**Subject:** *Comment Response Letter  
 PA 20-007, Ray townhomes 2<sup>nd</sup> technical review.*

We are pleased to submit this letter and the accompanying documents in support of our proposed development of Ray Townhomes at 9820 55th Avenue NE. These submittal documents are provided in response to a review completion letter issued by the City of Marysville on July 2, 2020. PSD review comments contained in that letter are provided below (plain text), along with a response (**bold italics**) indicating how each comment was addressed.

ROAD & UTILITY PLAN

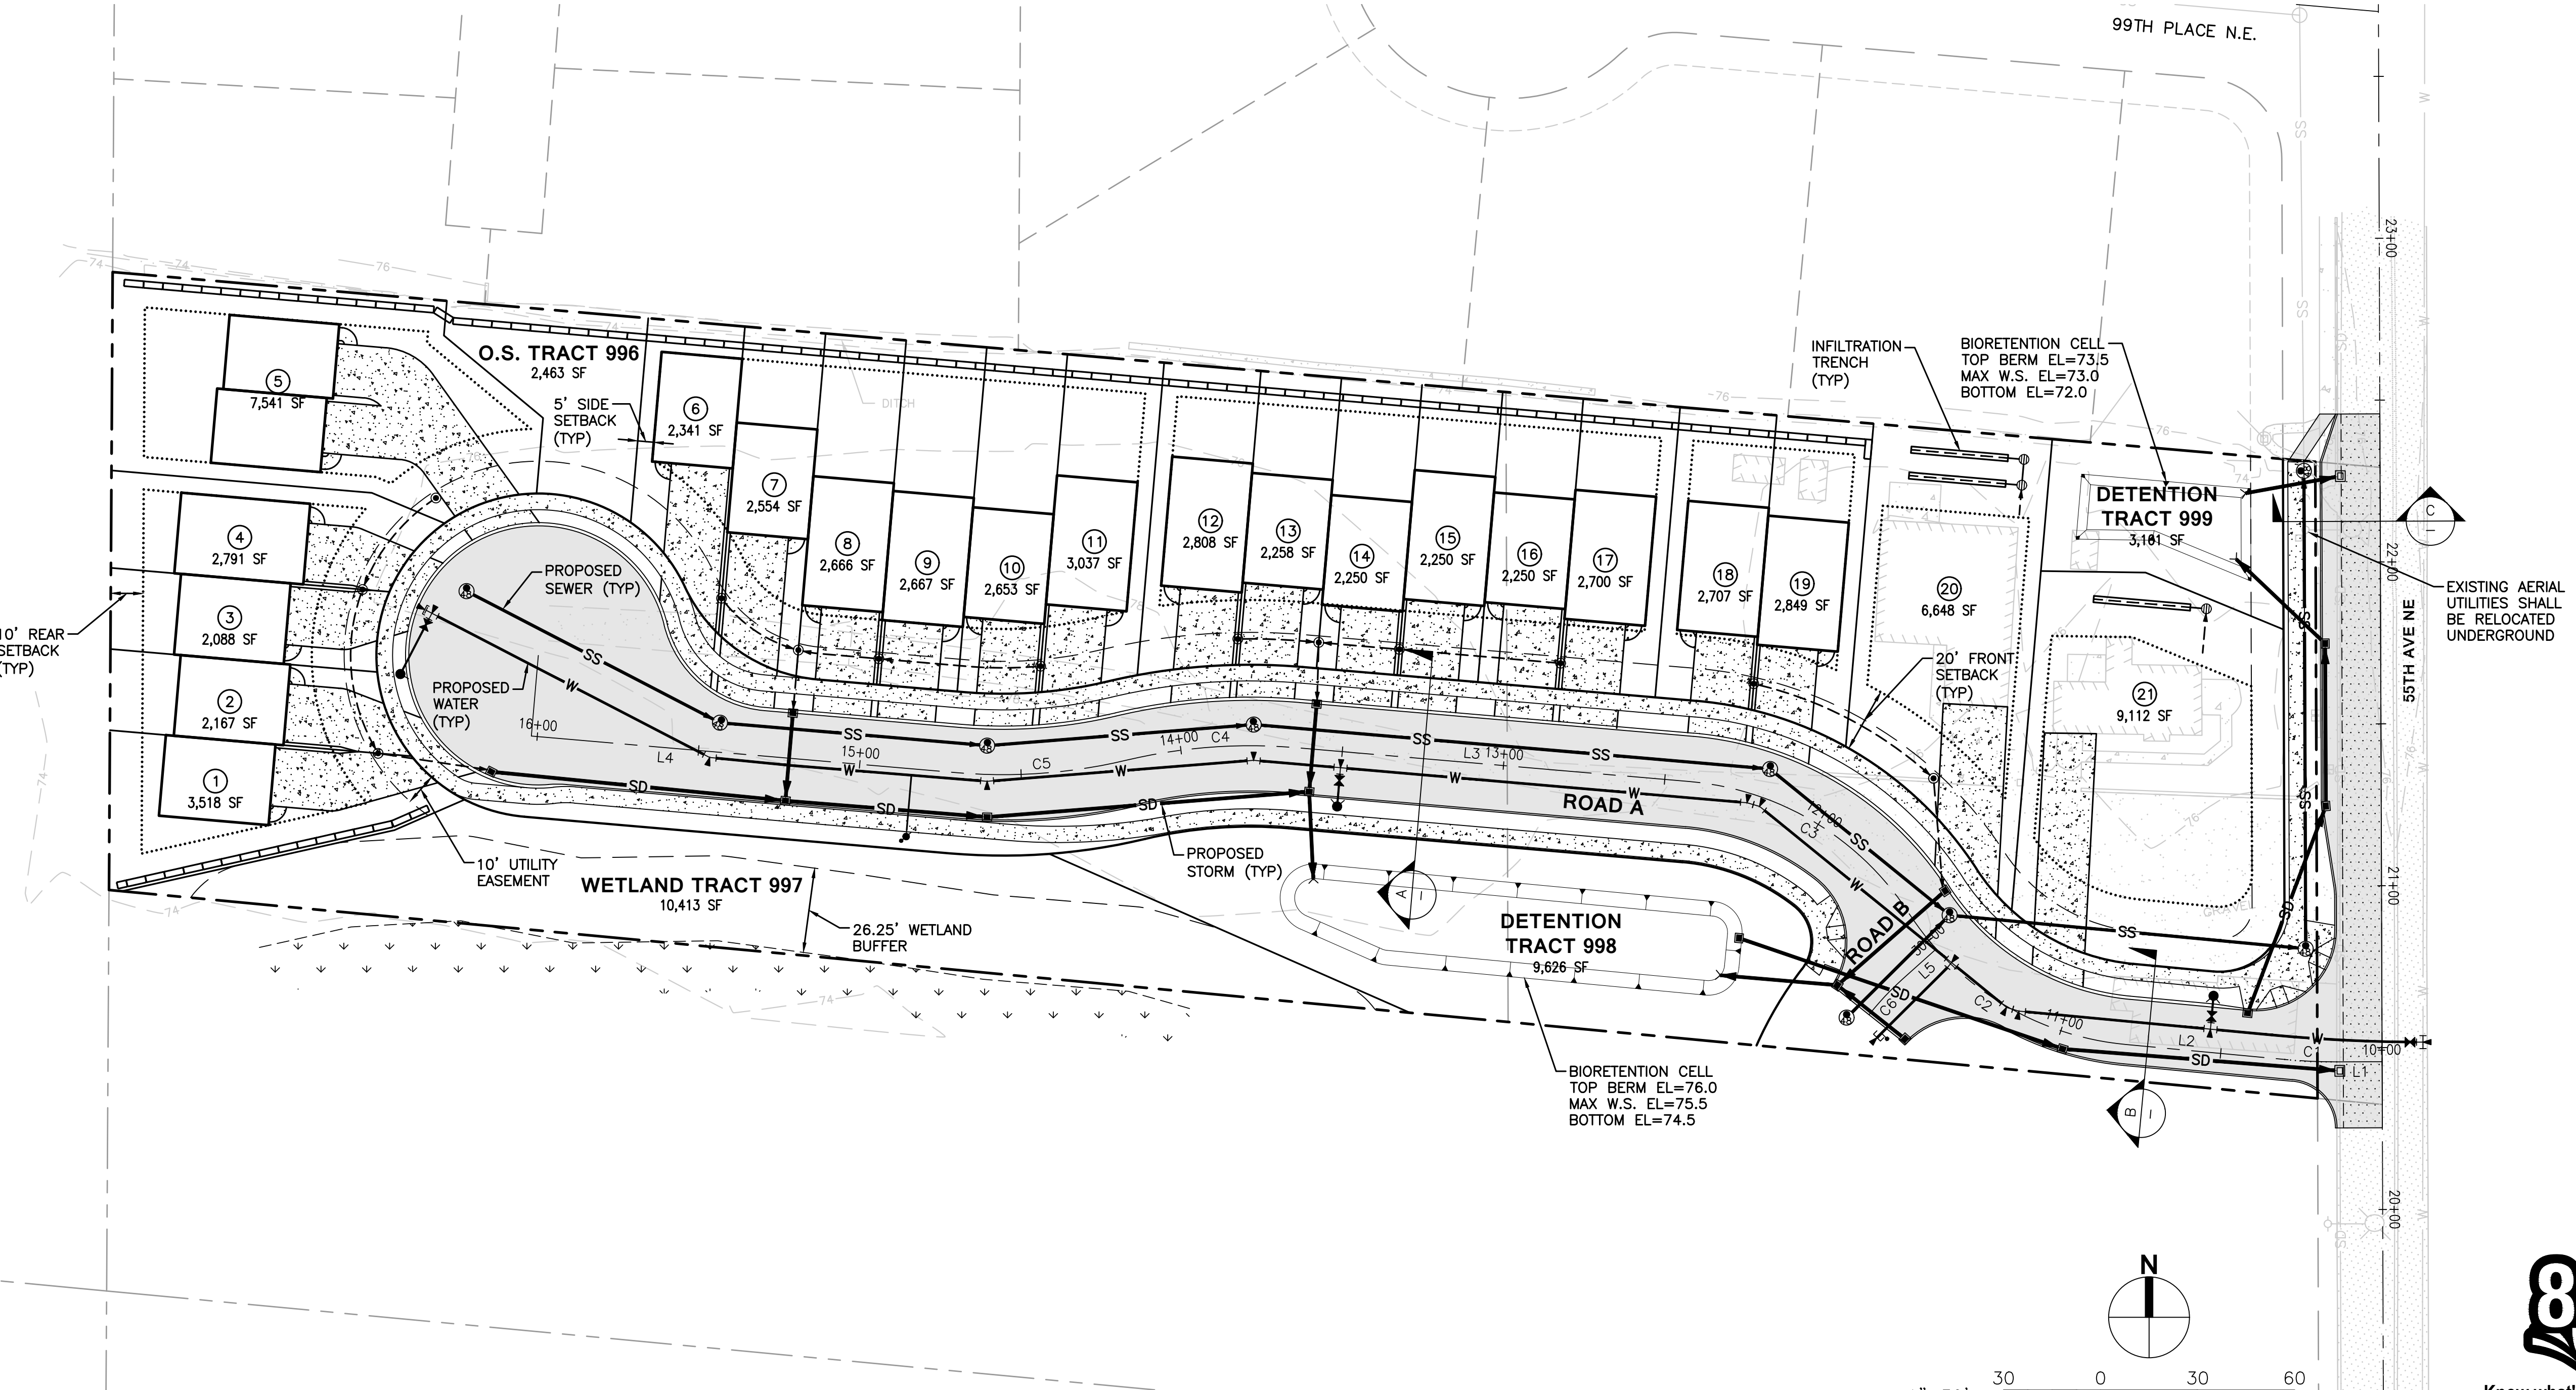
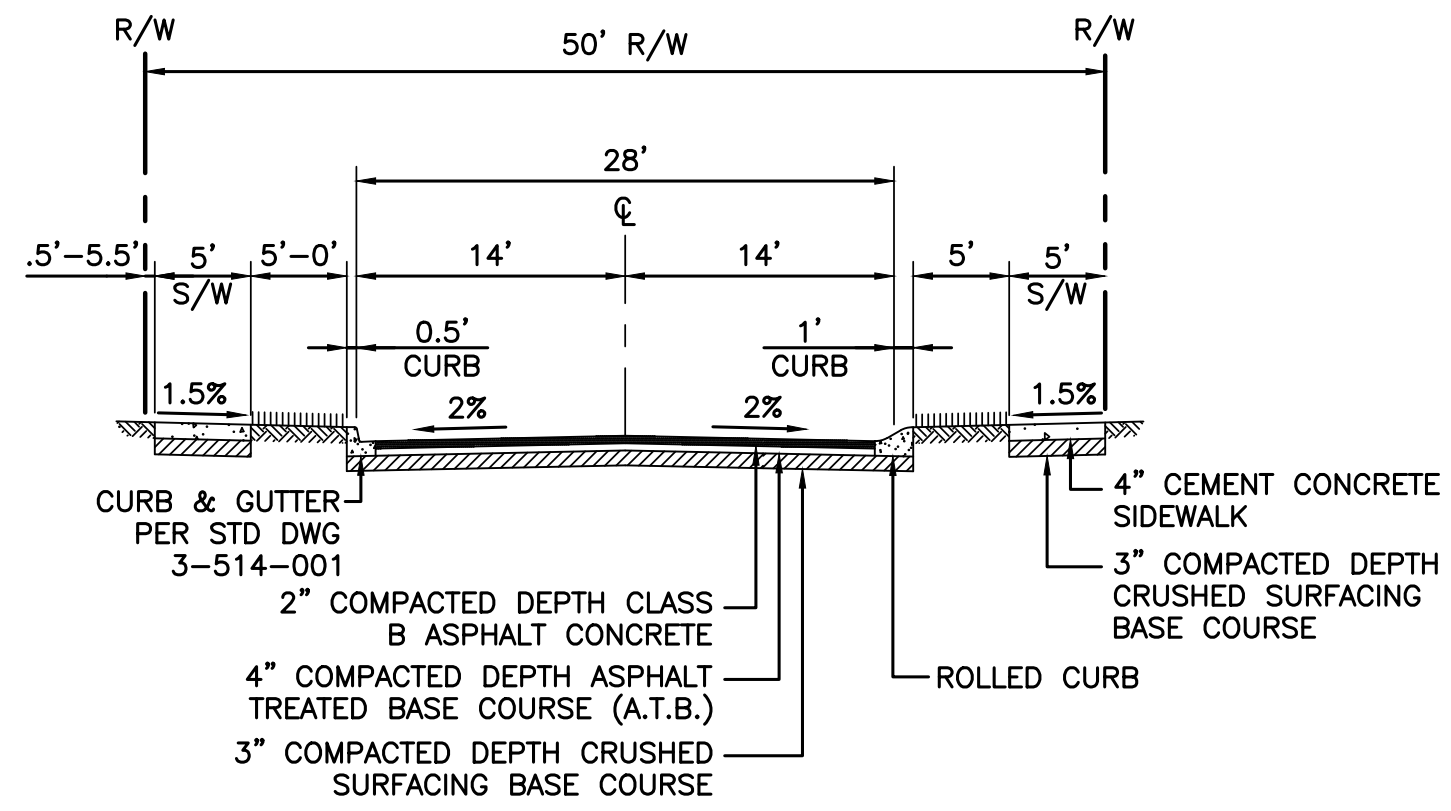
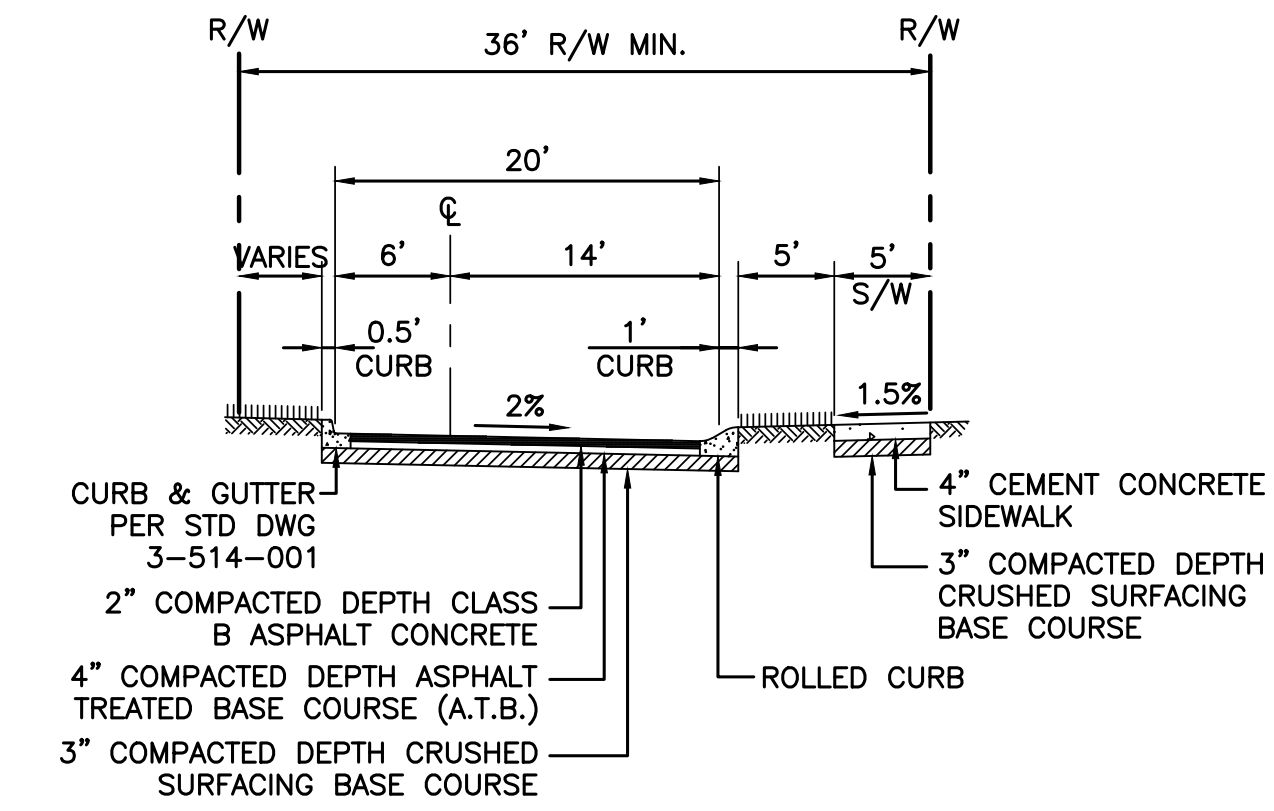
5. The drainage report references an overflow to 55th Ave for the storm facilities. I don't see any overflow for the bioretention pond. It should have an overflow if possible.

***Response: The bioretention facilities have overflows shown on sheet C4.0.***
